DECISION DELEGATED TO HEAD OF PLANNING

Application No: H09-0063-26 **Applicant:** Mr & Mrs Tatum
Proposal: Proposed Repairs & Alterations to Listed Building
Location: 3 Chancery Lane Holbeach Spalding
Terminal Date: 6th April 2026

Client:	Mr & Mrs Tatam	
Project:	Repairs & Alterations to Listed Building at:- 3 Chancery Lane, Holbeach	
Drawing title:	Elevations - As Proposed	
Scale:	1:100 @ A3	
Date:	JAN '26	
Proj. No:	Drawing No:	Revision:
1046	3003	A

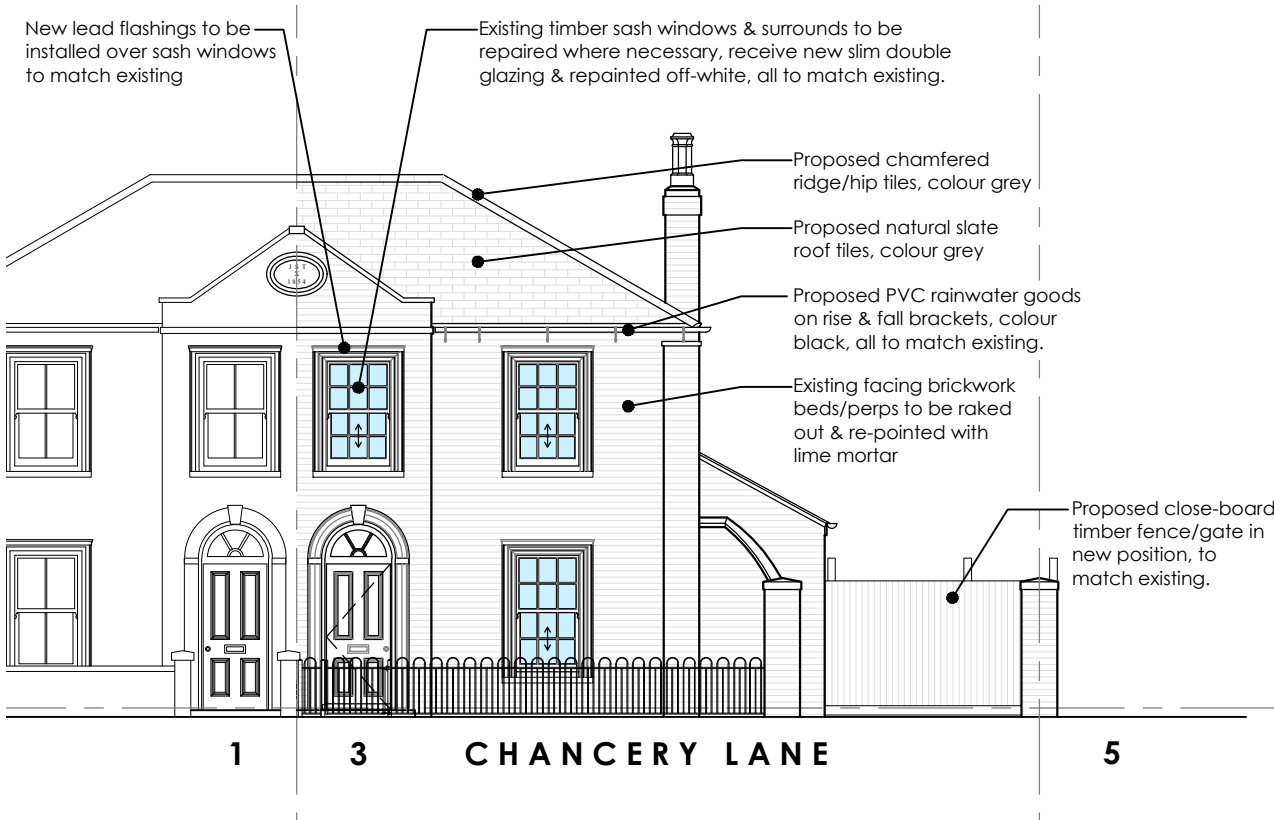
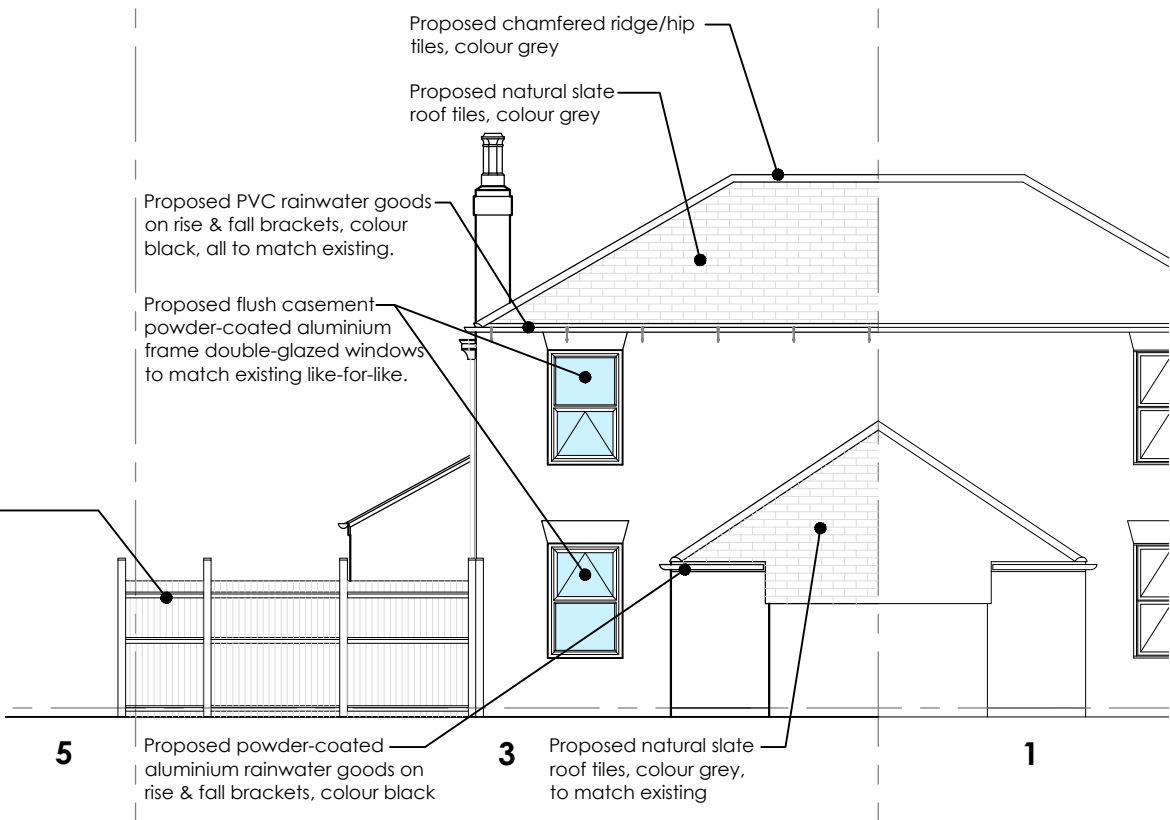
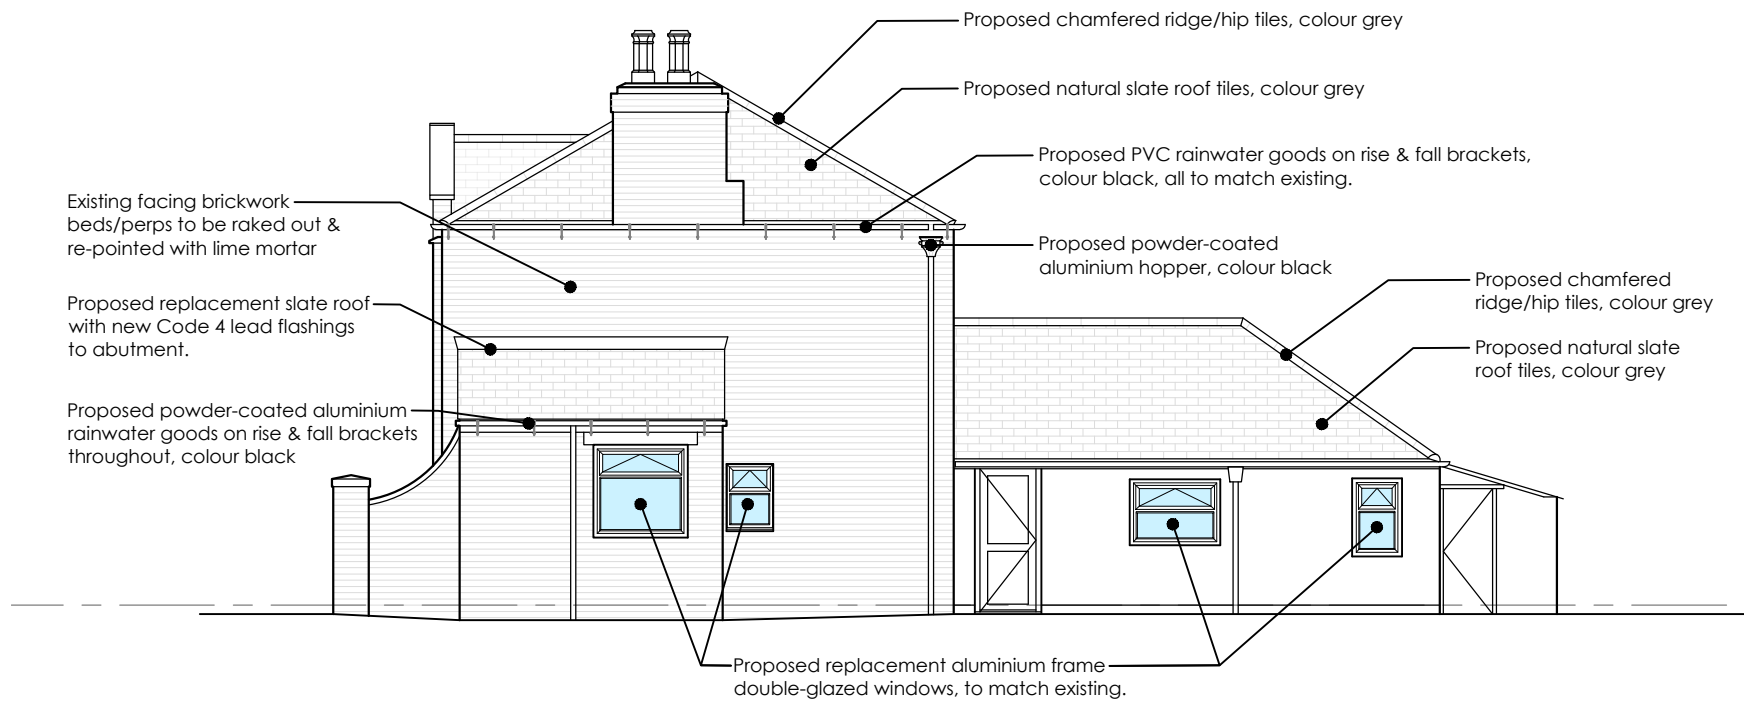
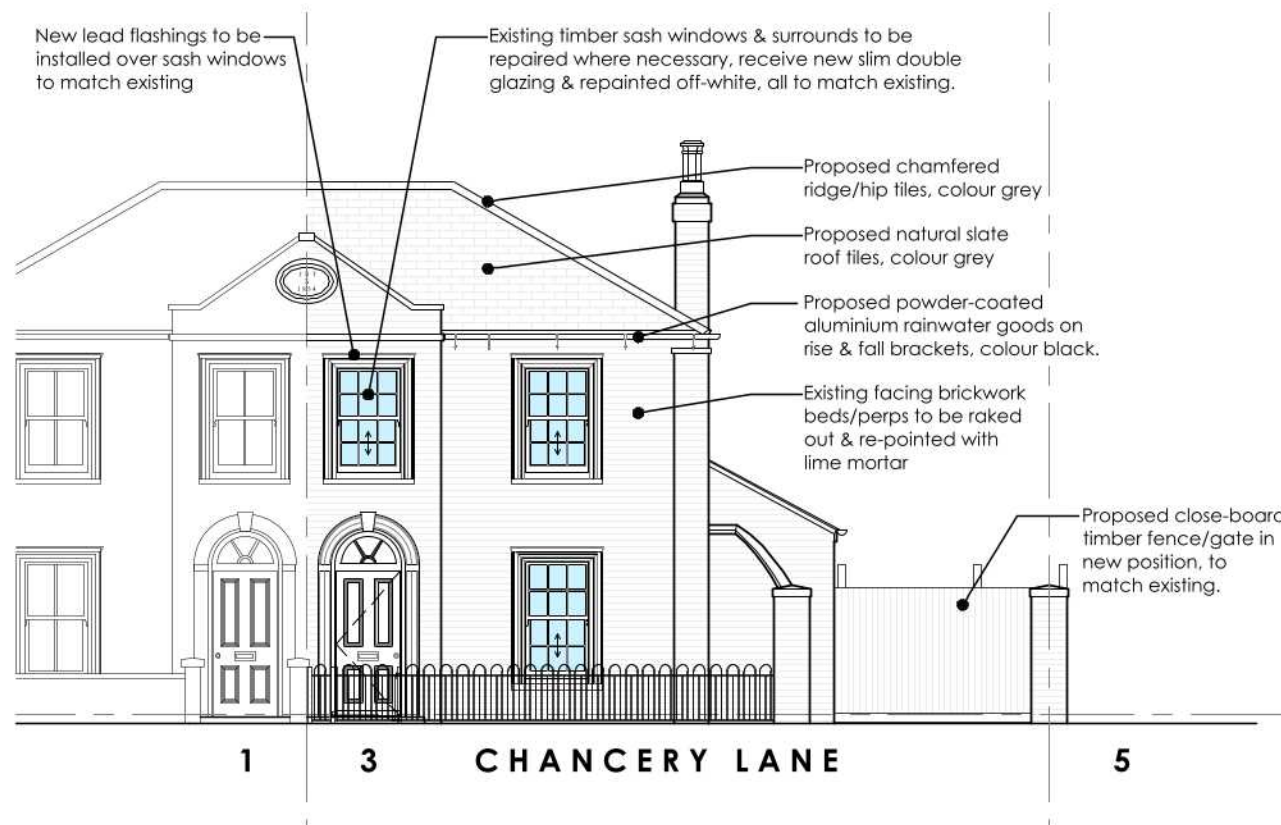
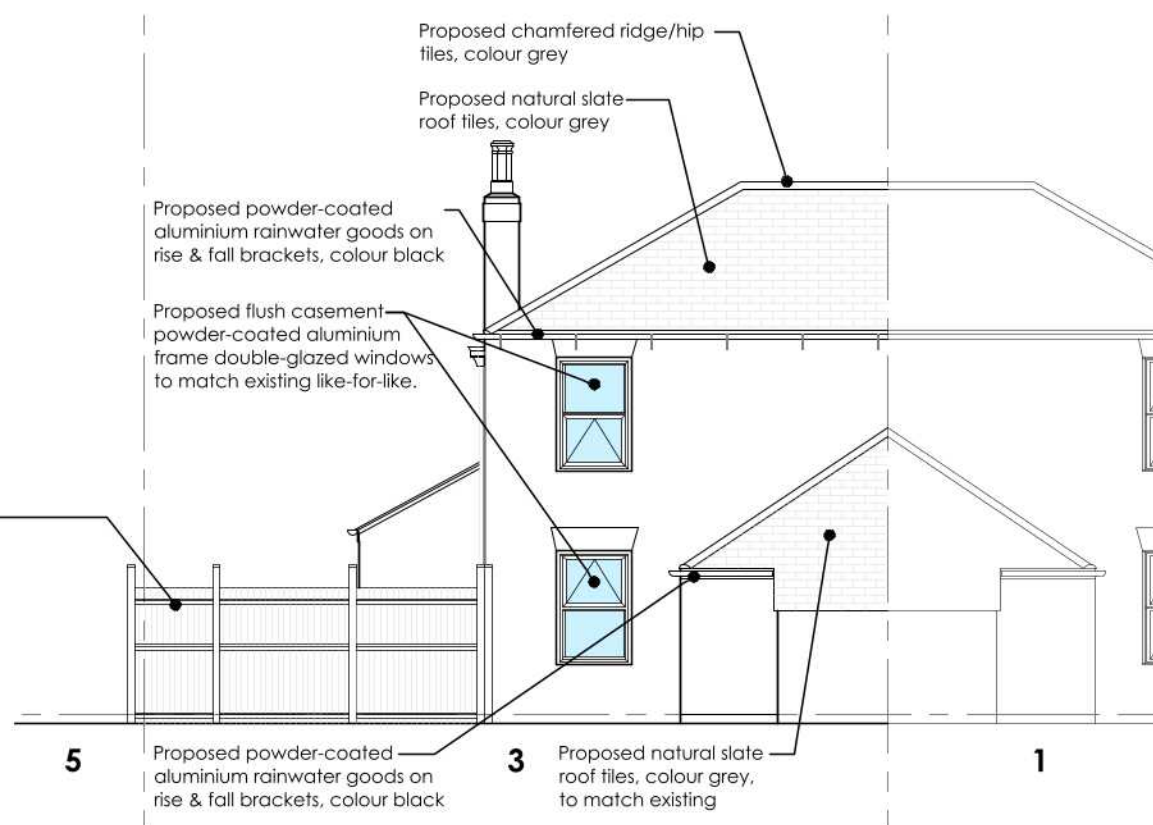
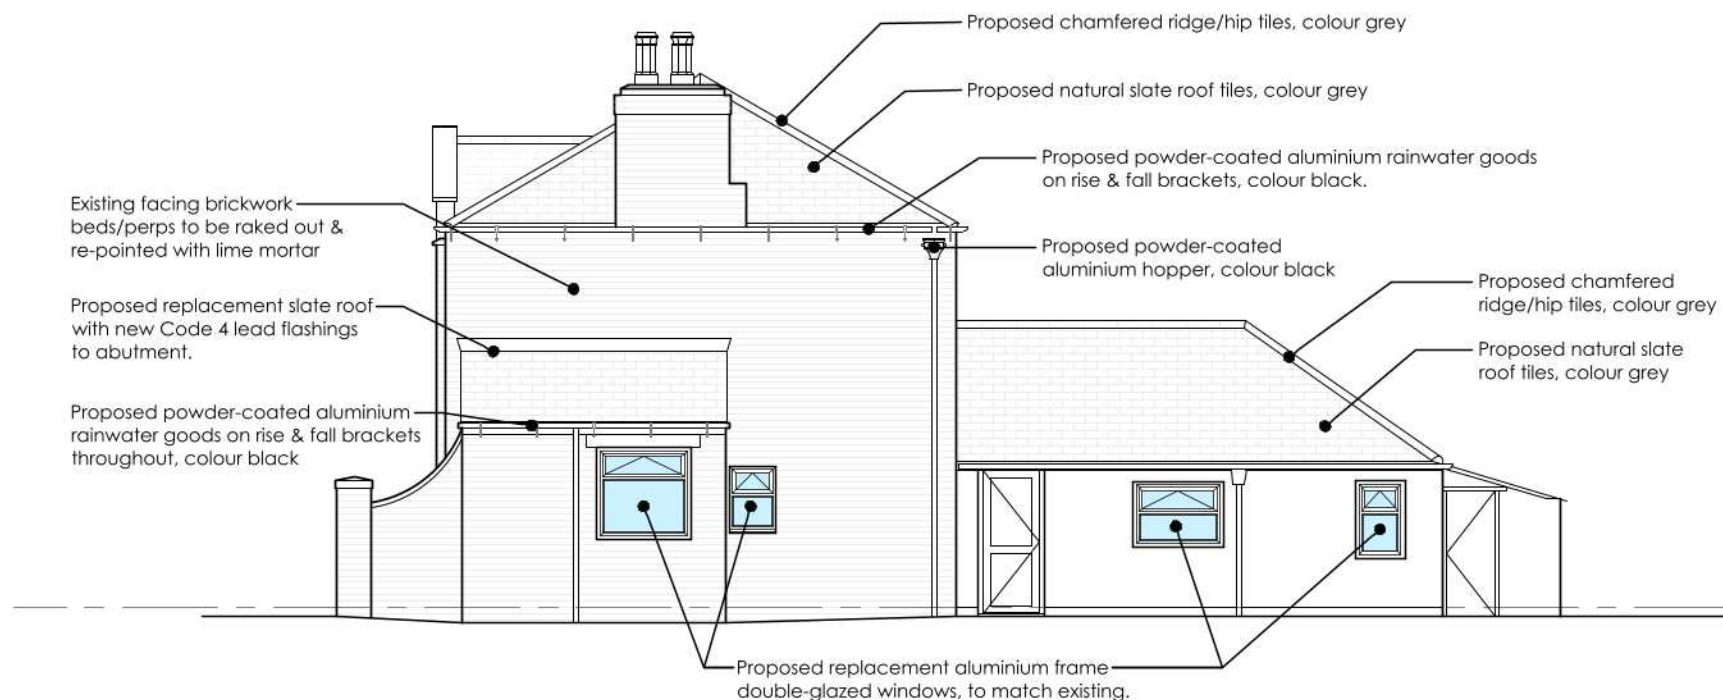
I am writing to confirm that I'm satisfied with all proposals included within both applications, apart from the proposed installation of PVC rainwater goods. UPVC is not an appropriate form of material for any aspect of a Grade II listed building, and as such does not 'match existing' as the plans suggest. The applicant has proposed to use powder coated aluminium RWGs on the lean-to. The application should be amended to replicate the use of metal RWGs throughout, and if the applicant is not open to amendment, the application should be refused on grounds of unjustified harm to an LB by means of installation of a thoroughly modern and inappropriate form of material onto a designated heritage asset.

The proposal initially involved the replacement of rainwater goods with UPVC; however, following the comments of the Conservation Officer, these were changed to aluminium.

It is proposed that appropriate aluminium rainwater goods would be used. These are considered appropriate given the nature of the asset. This aligns with the comments of the Conservation Officer.
